Reference No:	2023/62/93242/E
Site Address:	16, Middle Road, Westtown, Dewsbury, WF13 2QB
Description:	Erection of single storey front extension, hip to gable enlargement, front and rear dormers with second floor rear extension
Recommending Officer:	Jennifer Booth

DECISION - REFUSED

OFFICER REPORT

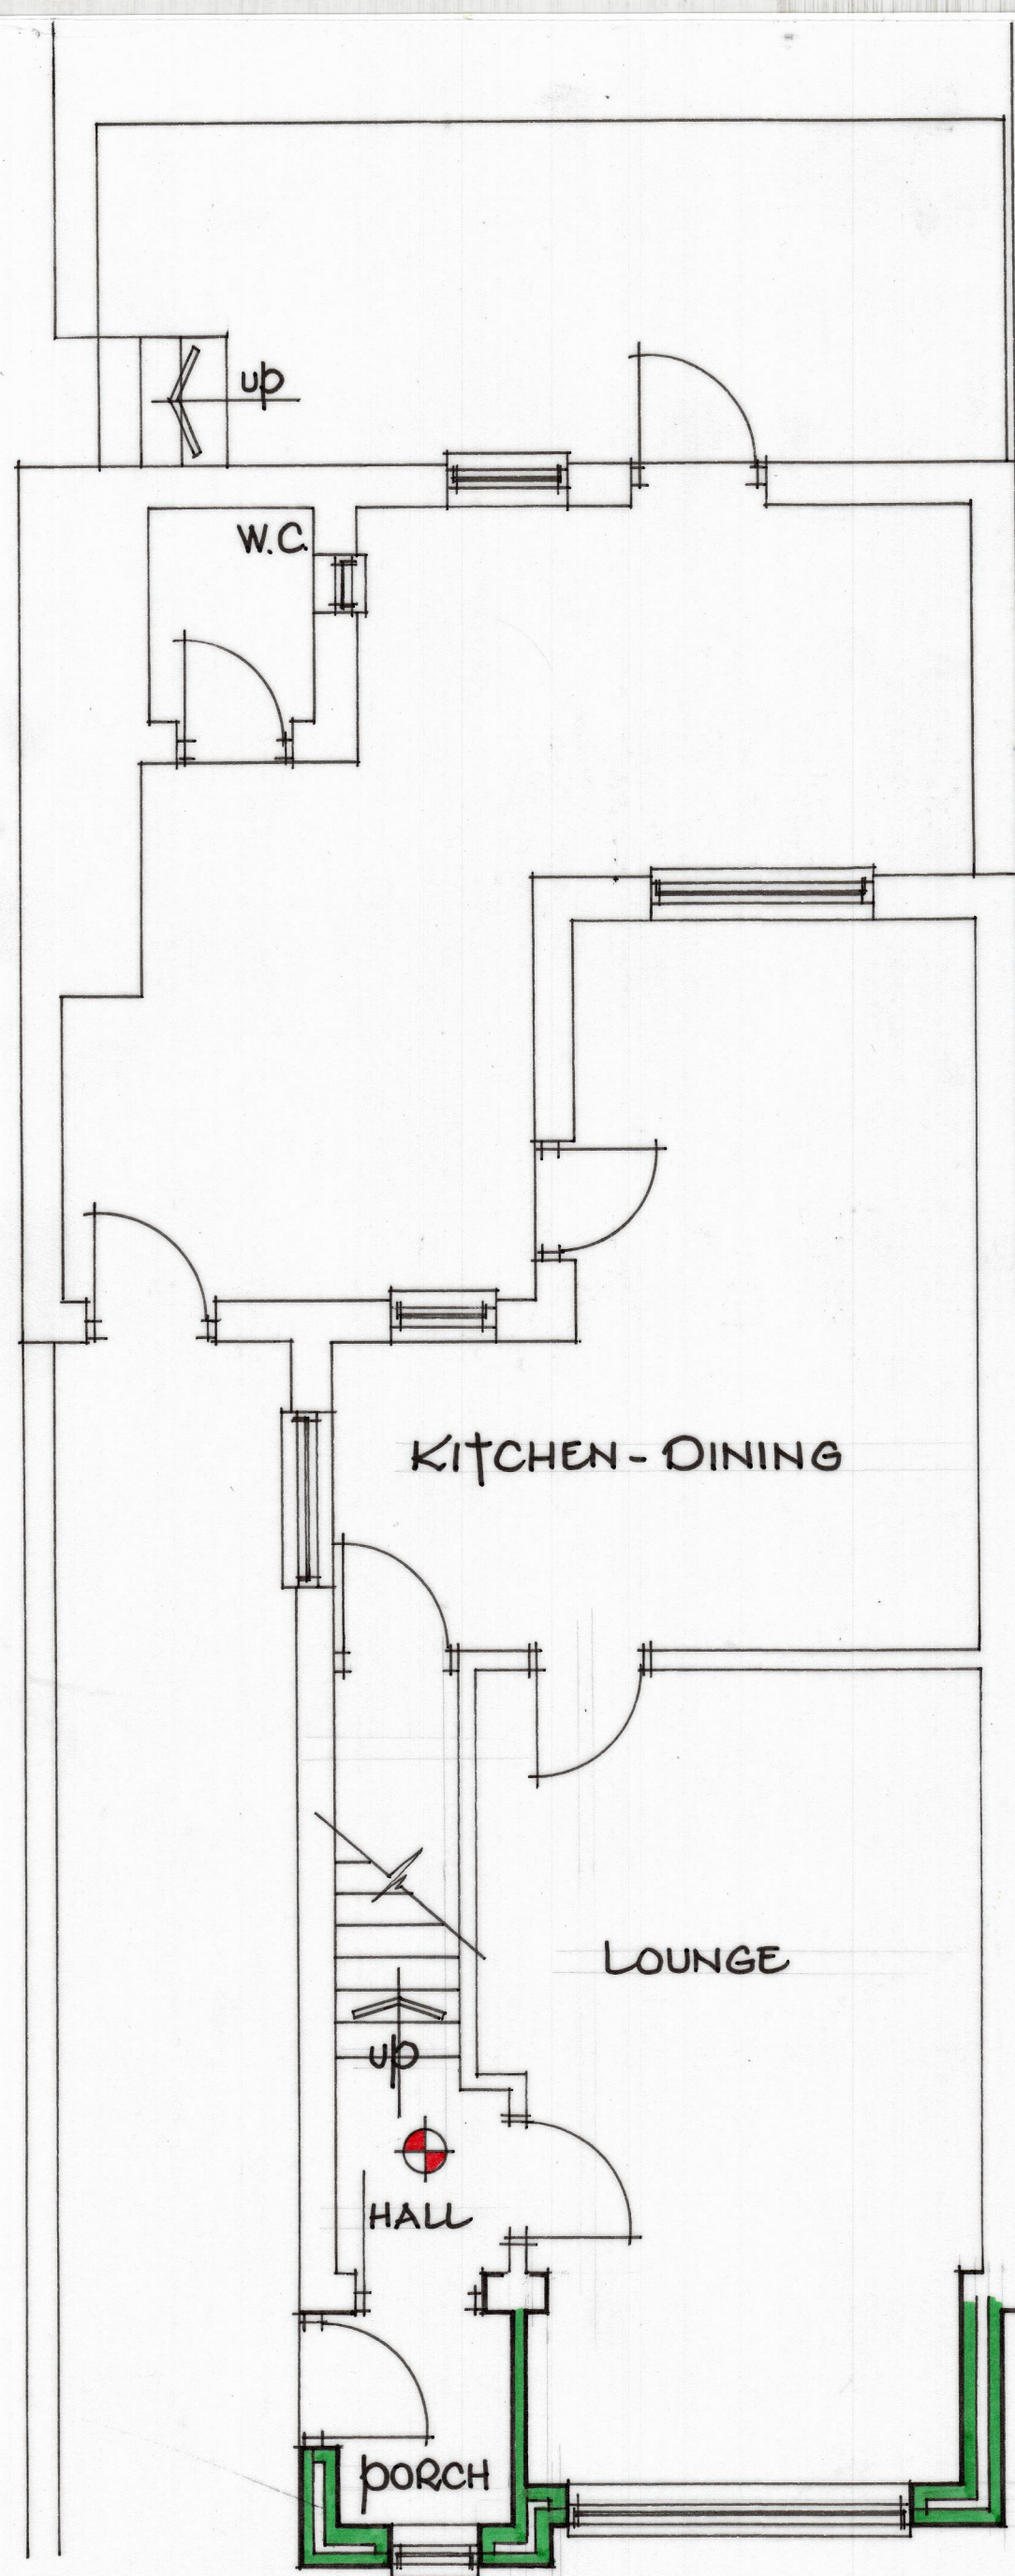
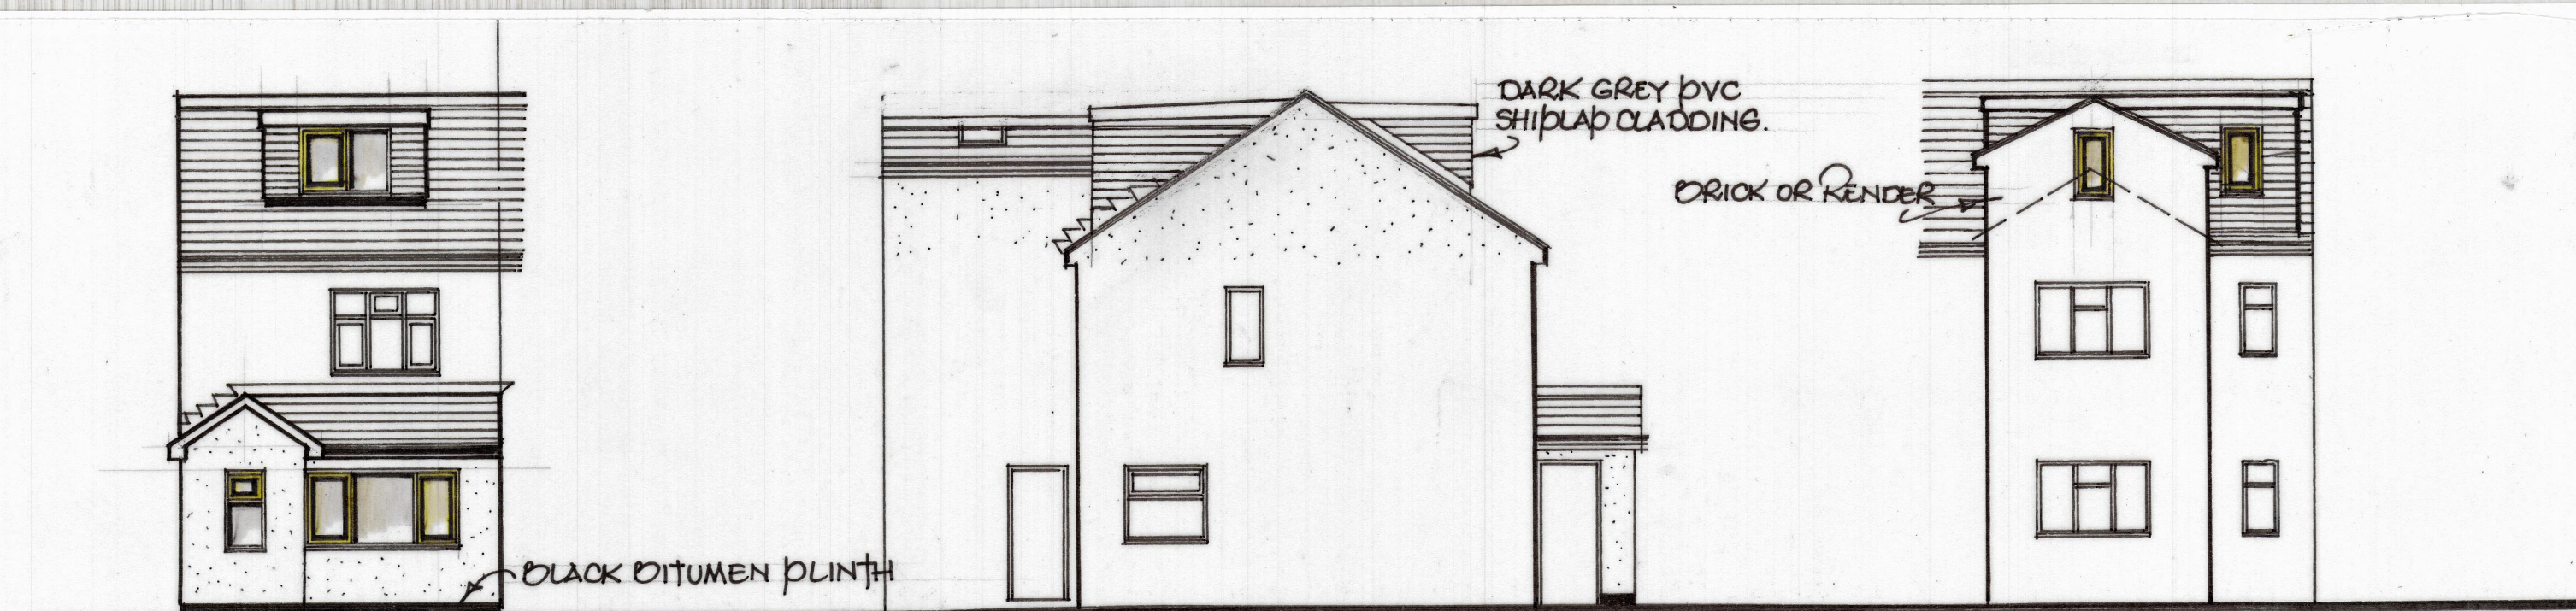
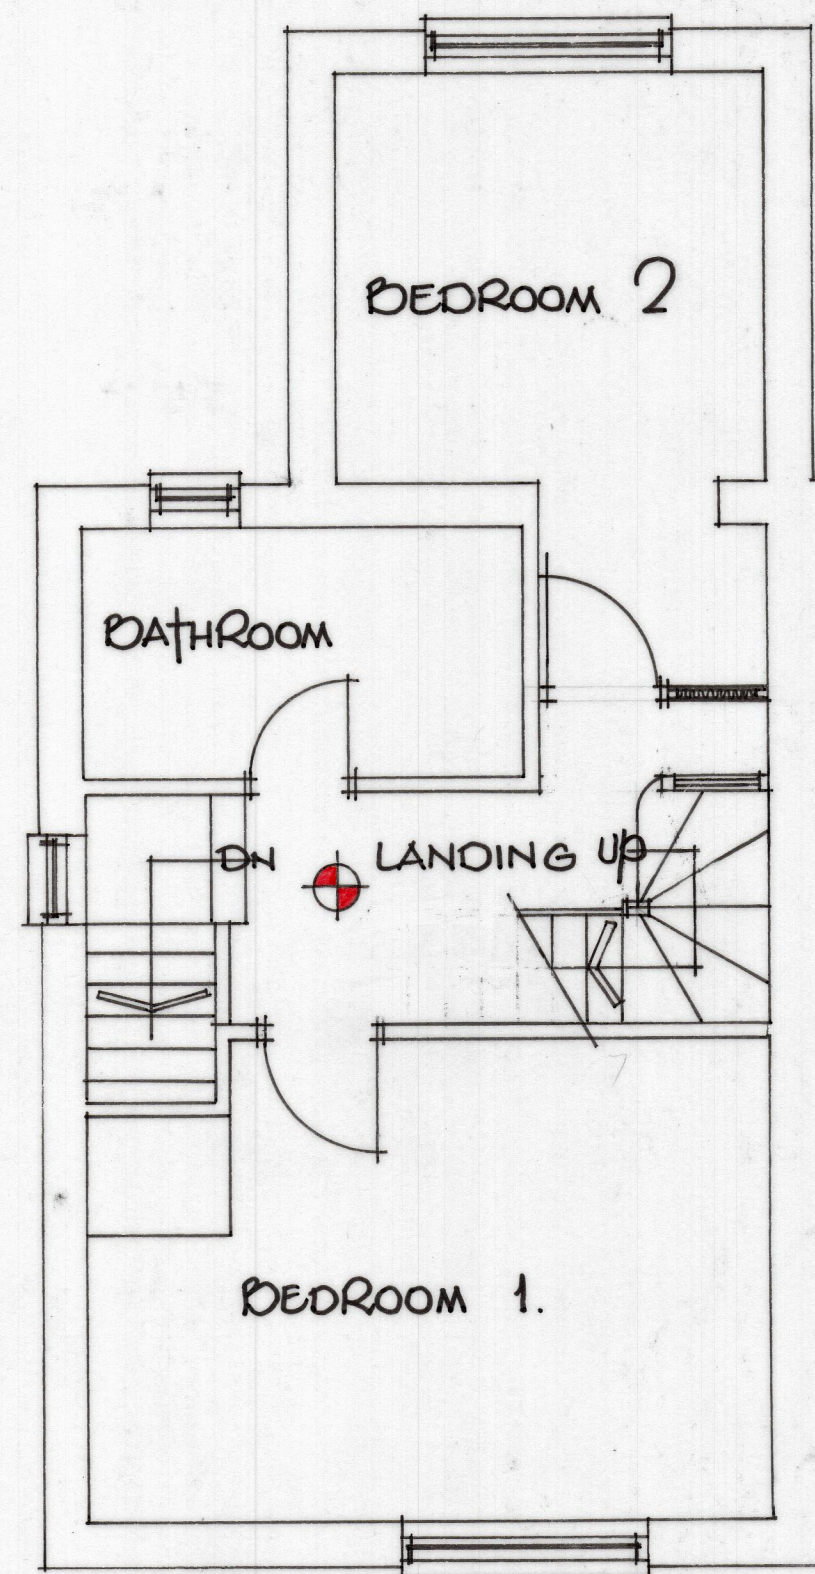
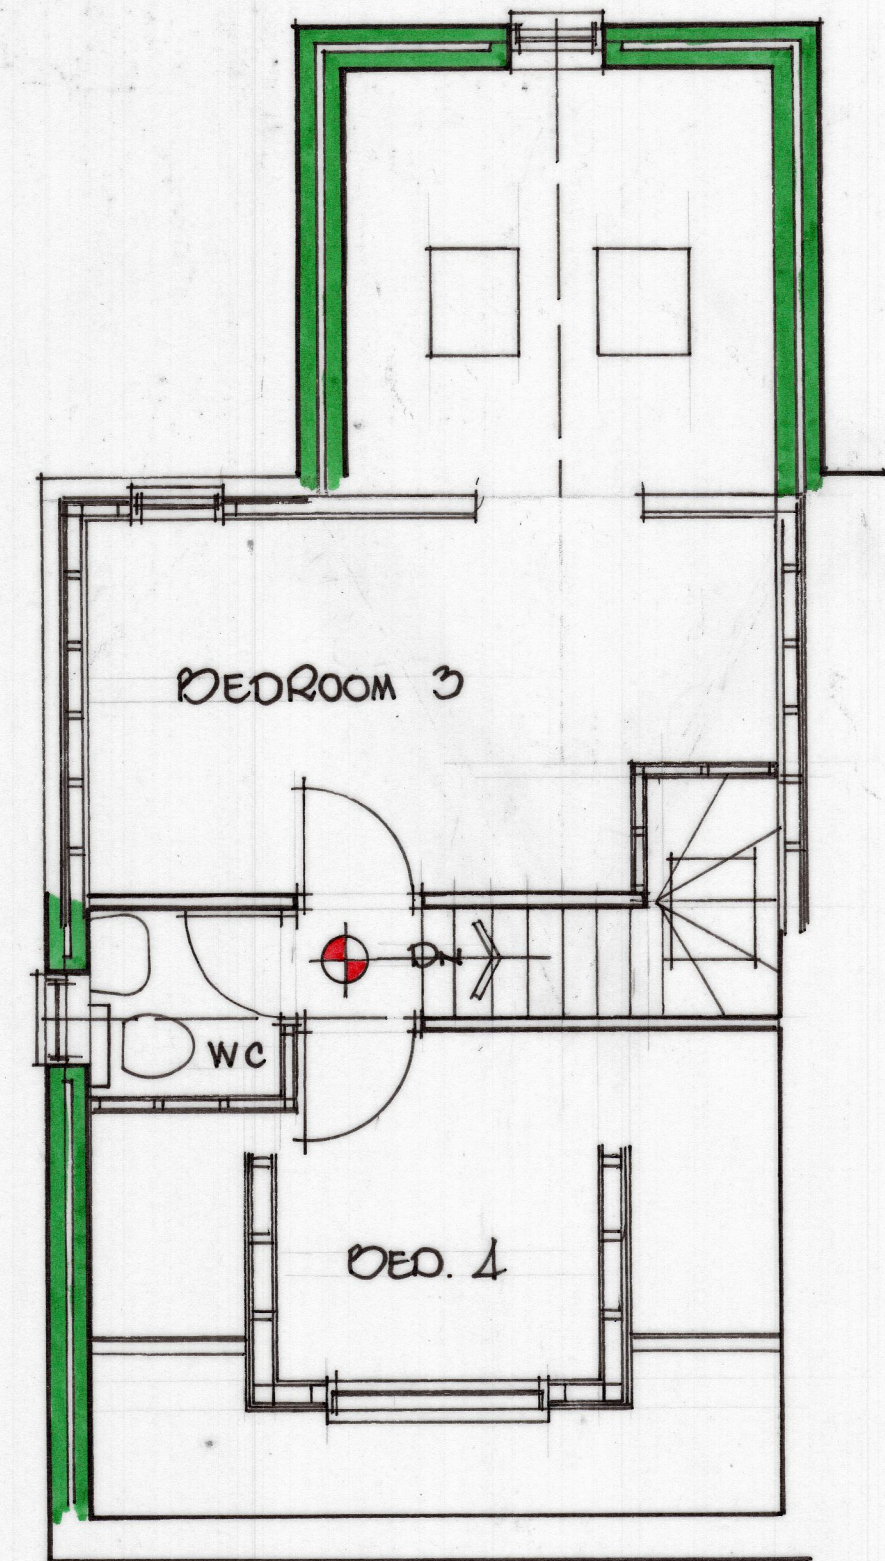
The other properties in the area have hipped roof forms and as such, the hip to gable enlargement would be out of character with the area and is not considered to be acceptable in terms of visual amenity.

In isolation, the front dormer might be considered to be acceptable given the limited size. However, as the dormer would rely on the hip to gable enlargement, this element of the scheme cannot be considered to be acceptable in terms of visual amenity.

Similarly the rear dormer now proposed is a very large addition in the rear roof plane, reliant upon the hip to gable enlargement and exceedingly prominent from the road at the rear. The rear dormer is not considered to be acceptable in terms of visual amenity.

Although the projection of the rear extension is limited to 3m and it would replace an existing substandard mix of rear extensions, the overall height of what in effect would form a three storey rear extension is inappropriate. Despite the use of a render finish, which would match the main house, the overall design and scale of the rear extension is not acceptable in terms of visual amenity.

The roof design including the hip to gable enlargement together with the front and rear dormers would appear discordant and incongruous in the street scene, failing to respect the original form and layout of the street scape,

adding an unsympathetic form of development that would detract from the host building and character of the area. To permit the roof alterations would be contrary to Policy LP24 of the Kirklees Local Plan, KDP1 & KDP2 of the House Extensions & Alterations SPD and chapter 12 of the National Planning Policy Framework.

The rear extension, by reason of the poor design, in particular the eaves height and three storey appearance would be out of character with the host property and wider area. To permit the rear extension would be contrary to Policy LP24 of the Kirklees Local Plan, KDP1 & KDP2 of the House Extensions & Alterations SPD and chapter 12 of the National Planning Policy Framework.

The cumulative impact of the front extension, roof alterations and rear extension would result in a development which is not subservient to the main house and would be out of character with the wider area. To permit the proposals would be contrary to Policy LP24 of the Kirklees Local Plan, KDP1 & KDP2 of the House Extensions & Alterations SPD and chapter 12 of the National Planning Policy Framework.
